Subject: EIS - First Building Bradfield City Centre (SSD-25452459) (Liverpool City)

Attachment A – EES Waterway health comments for the First Building Bradfield City Centre (SSD-25452459)

Comments are specific to Section 3 – Stormwater Management of the Bradfield Civil Design Report and the relevant Civil Engineering Plans provided at Appendix D of the EIS.

STORMWATER DRAINAGE PLAN

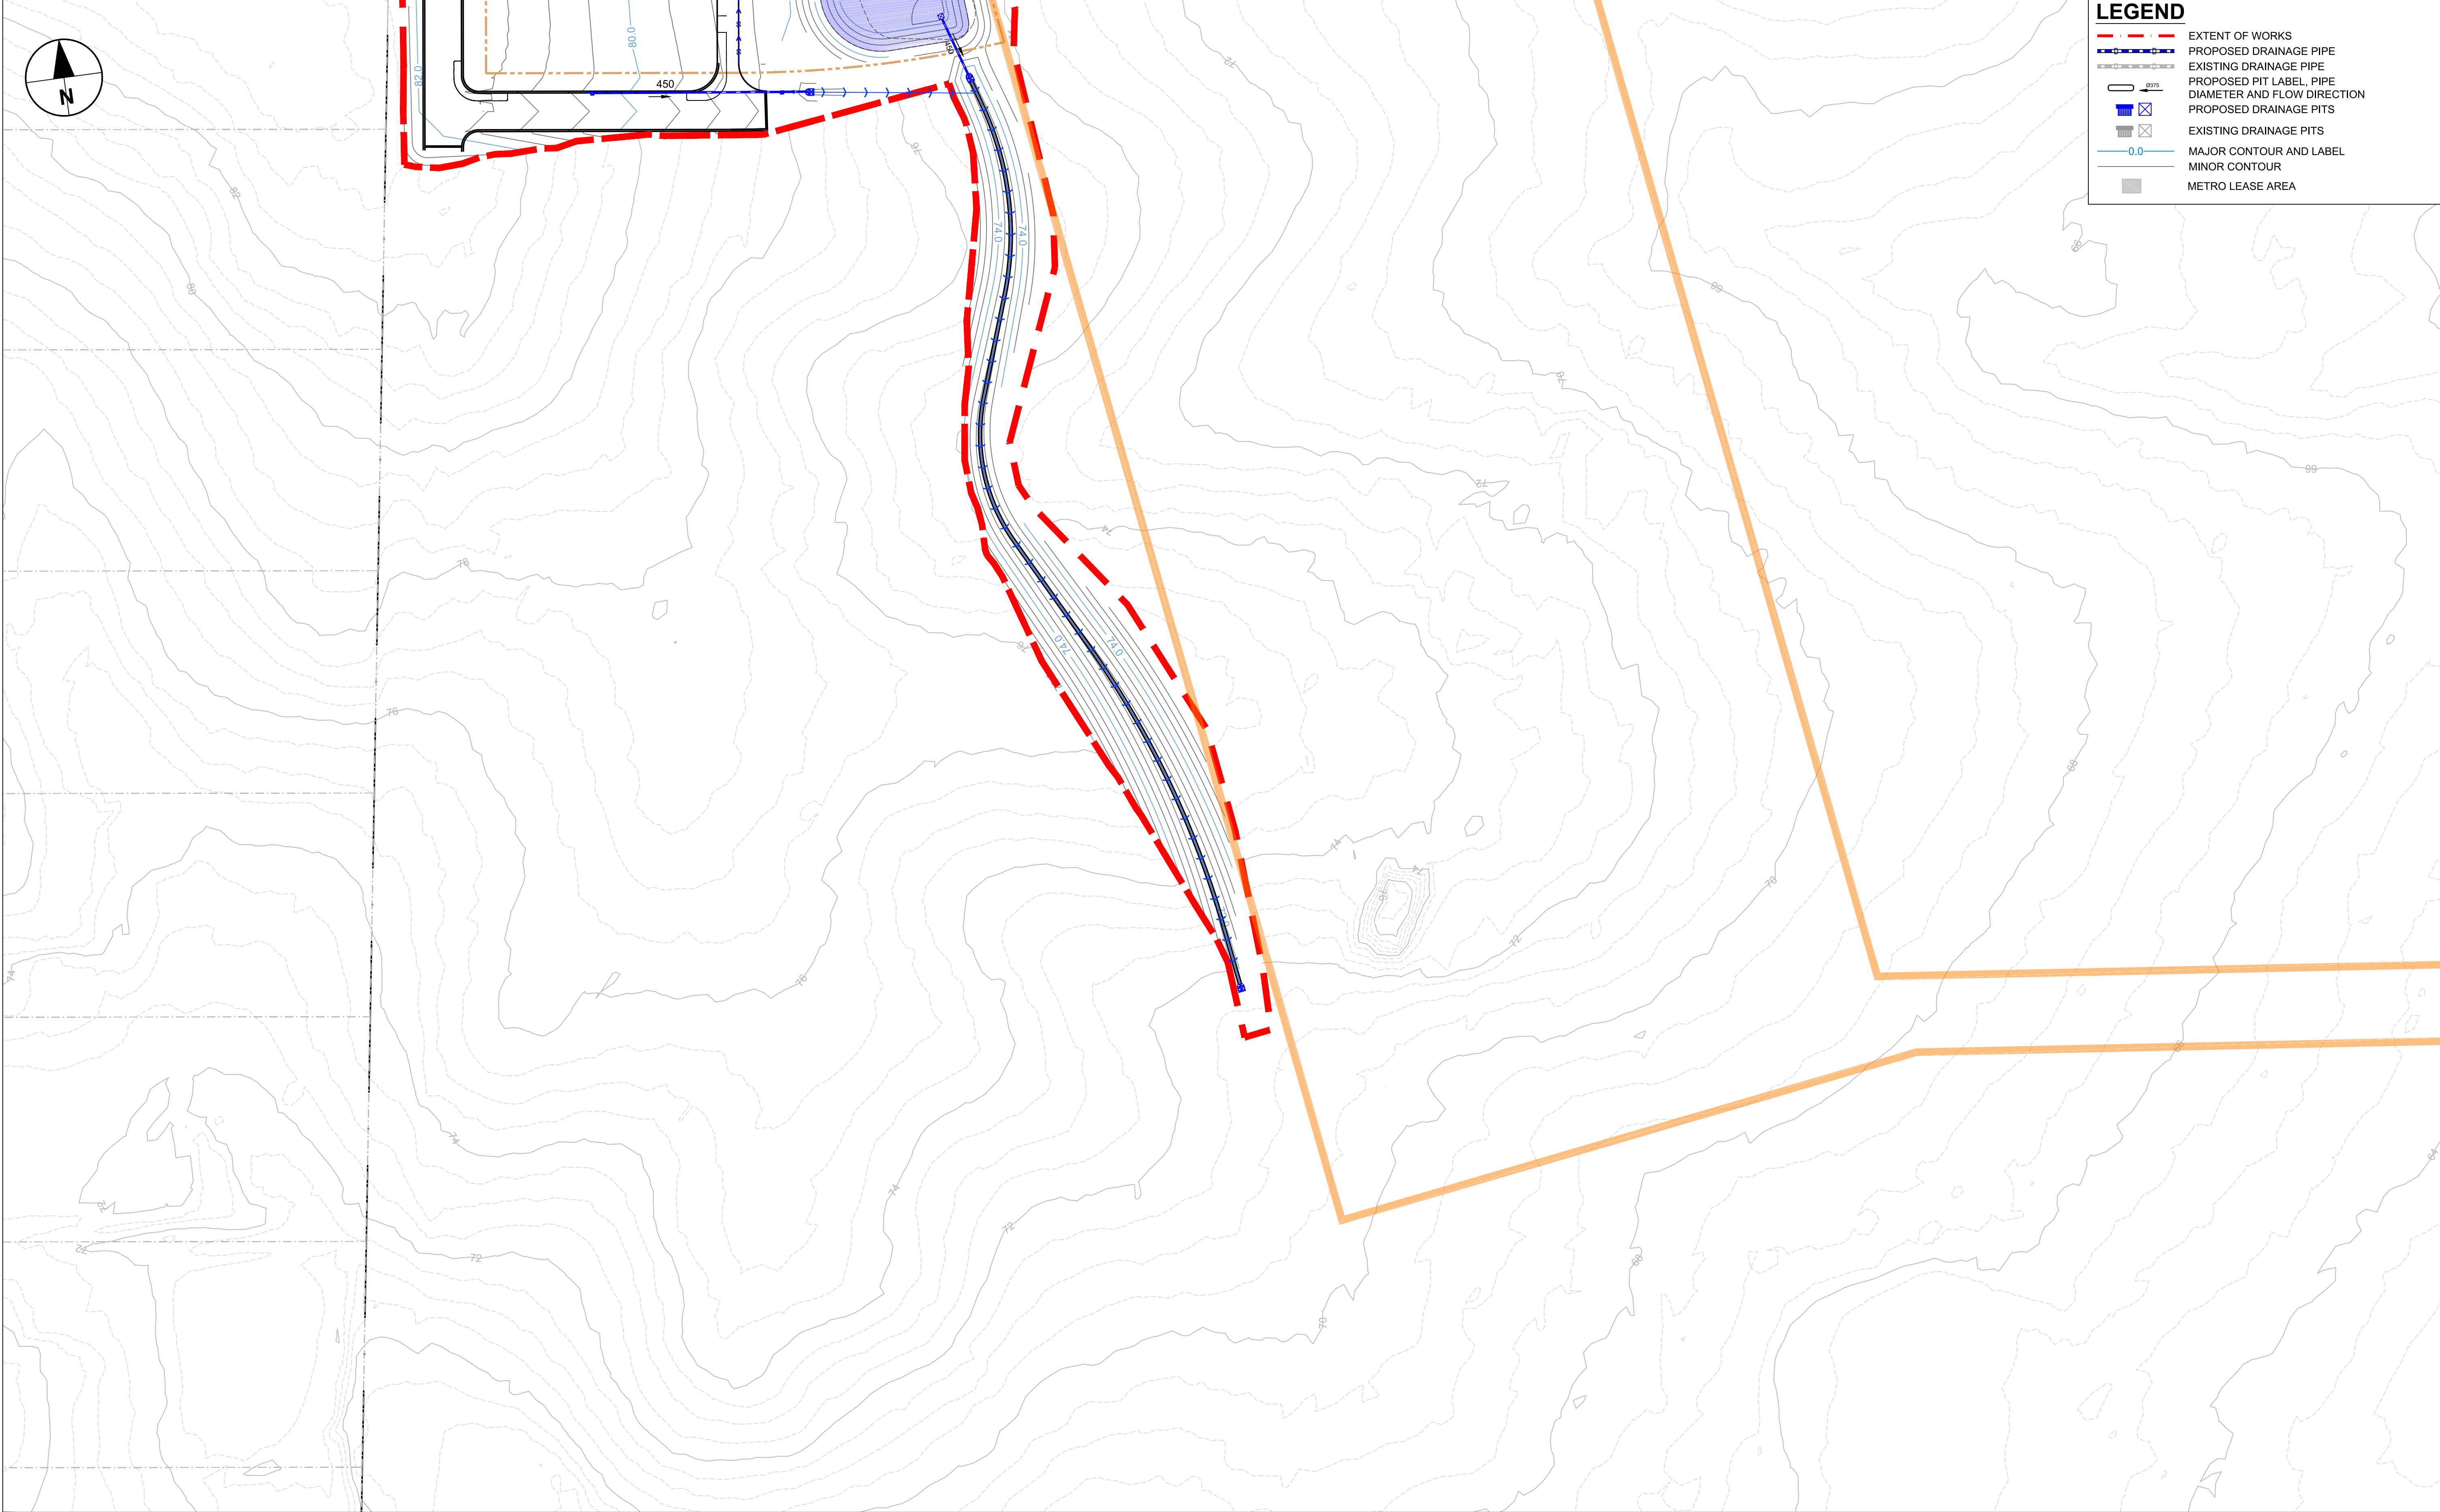
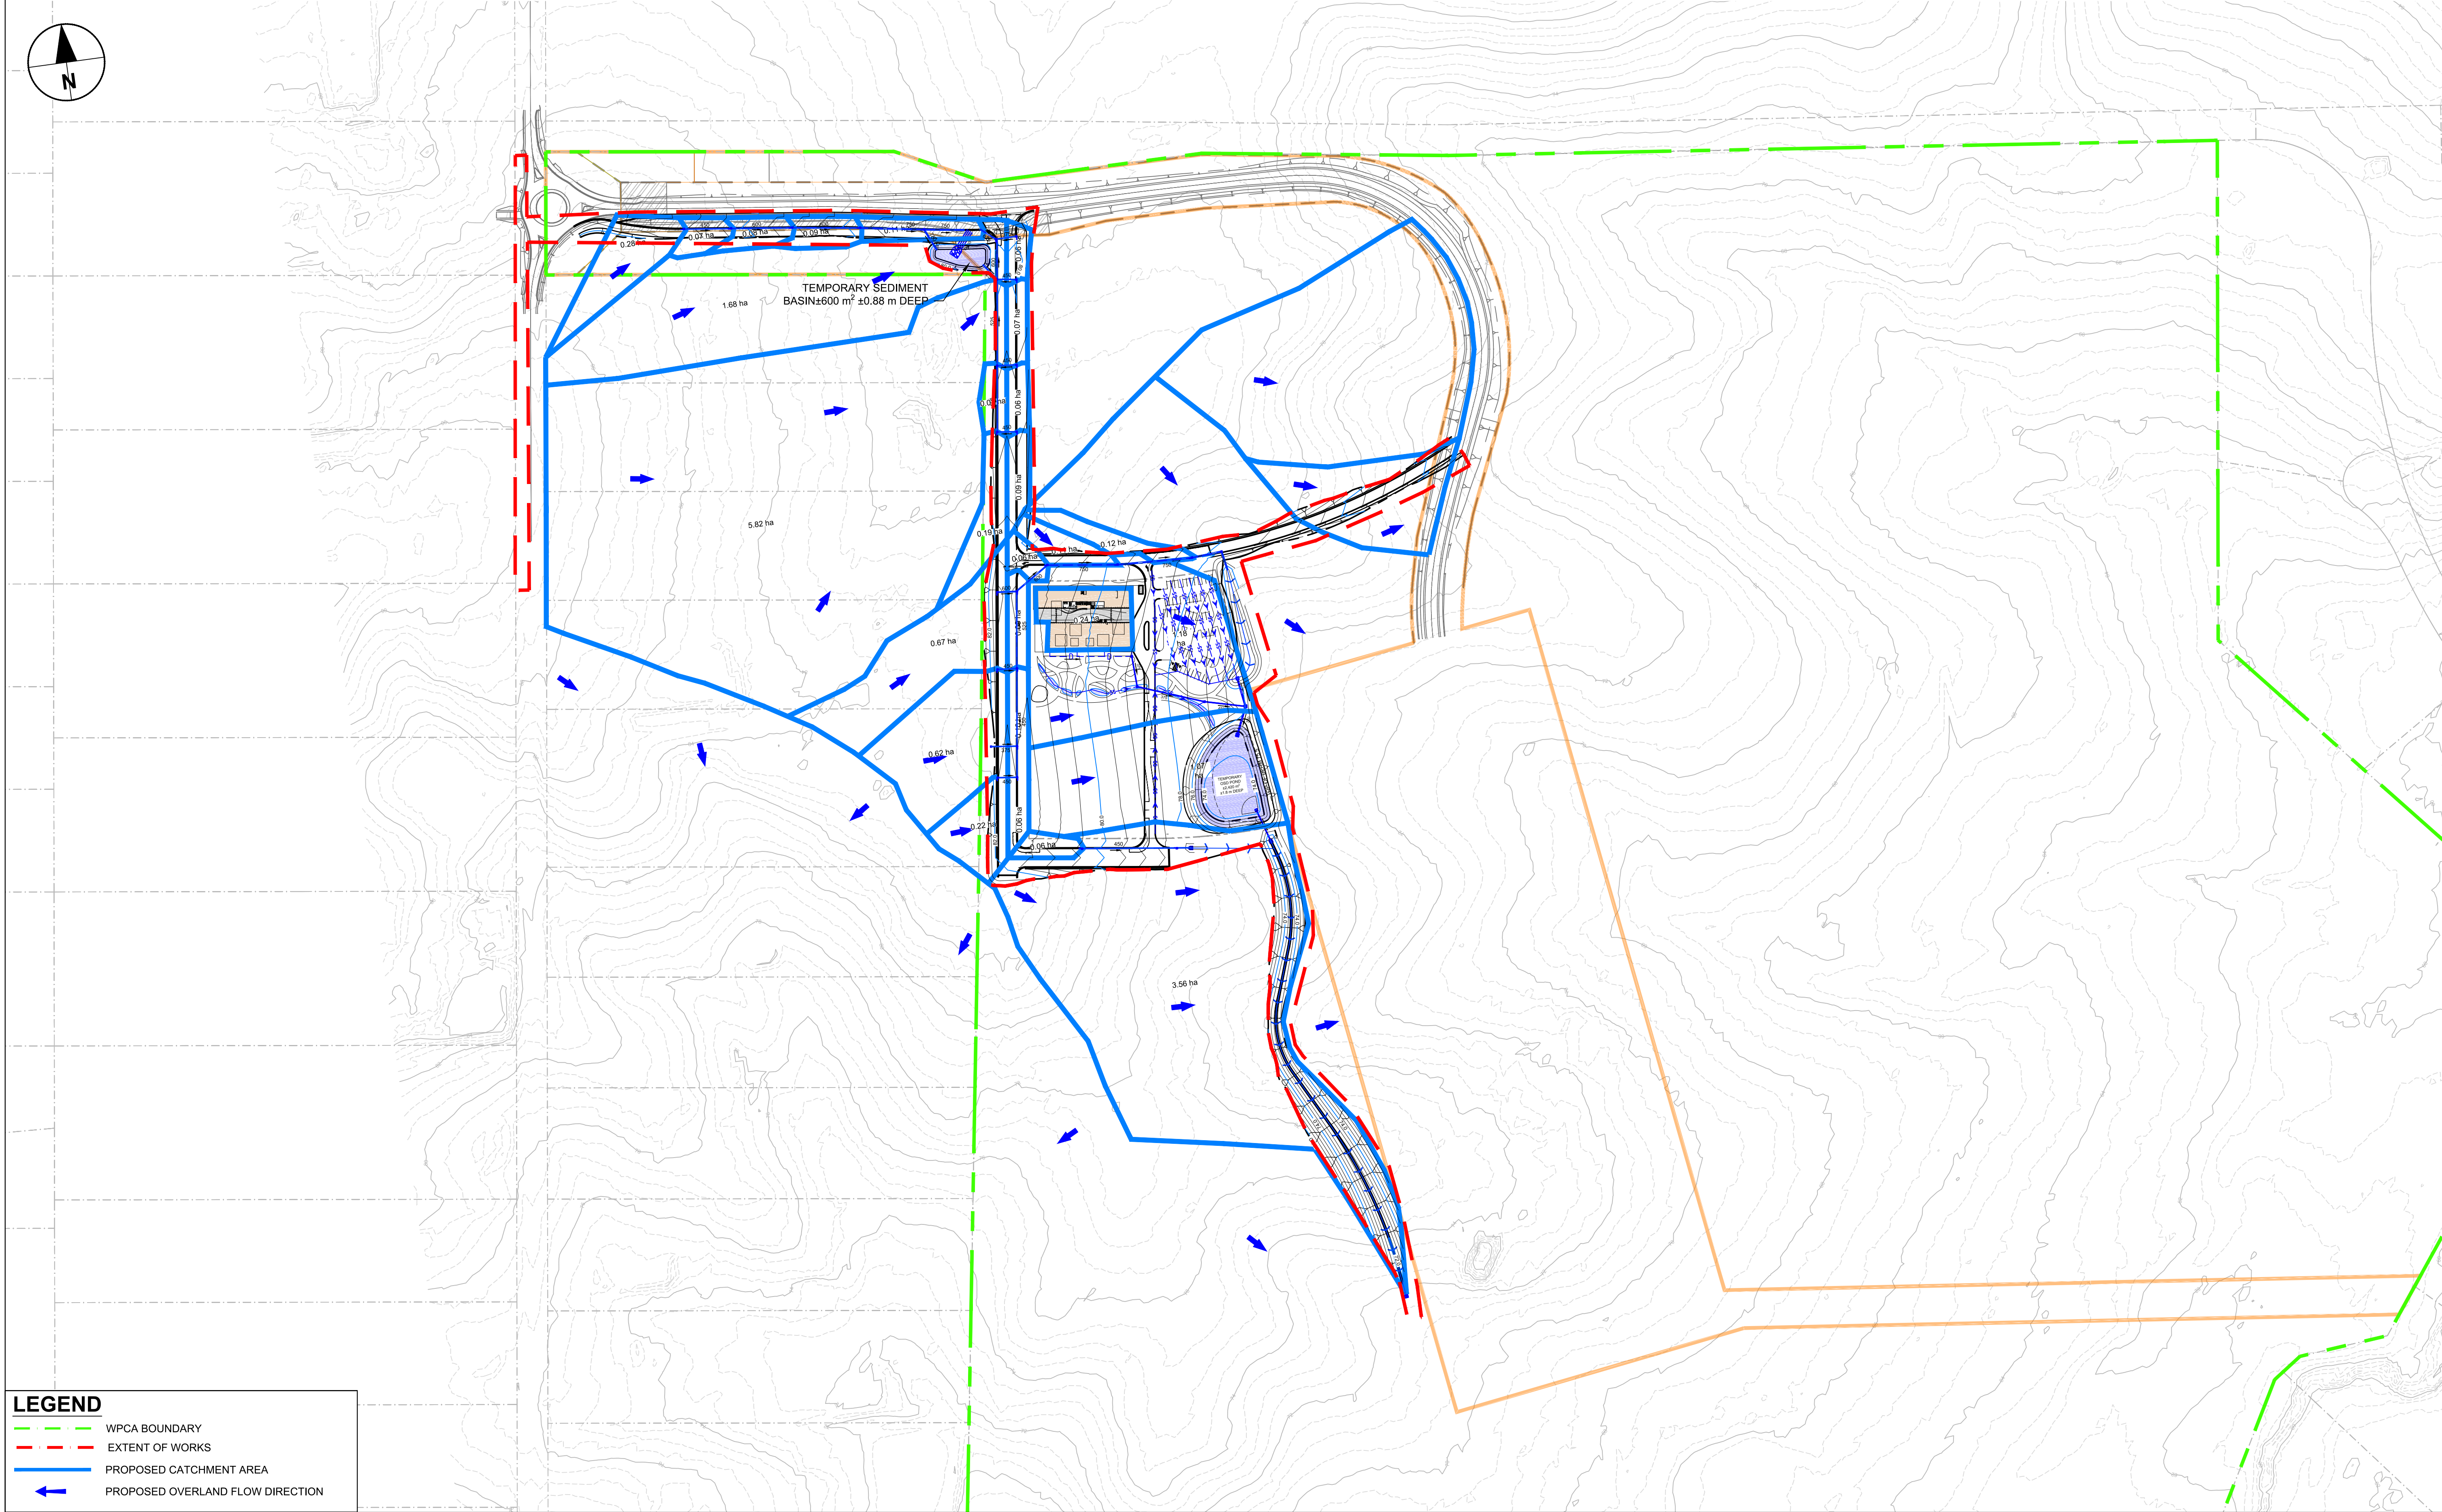
- A bioretention system located within the detention basin is proposed for the southern catchment. However, the design of the basin is inconsistent with toolkit and should be amended accordingly. It also is recommended that the following contemporary design guidelines be adopted in the revised EIS:

- 800m² surface area (~3% of development catchment)
 - 800mm extended detention – too large, must be 300mm max. Note the extended detention of the bioretention does not form part of the OSD volume as will likely be full of water when storm burst occurs

- 120m² filter media area (0.5% of development catchment)
 - hydraulic conductivity 2.5mm/hour – too low, must be 100mm/hr
 - 300mm filter media – too low should be 600mm (400mm min).

- base not lined – should be lined with impermeable liner to avoid infiltration in the potential saline/sodic soils.
- No conceptual design of the stormwater management systems is provided in the Civil Design Report and Civil Engineering Plan to illustrate levels, hydraulic drainage levels, volumes, interfaces, drainage information.
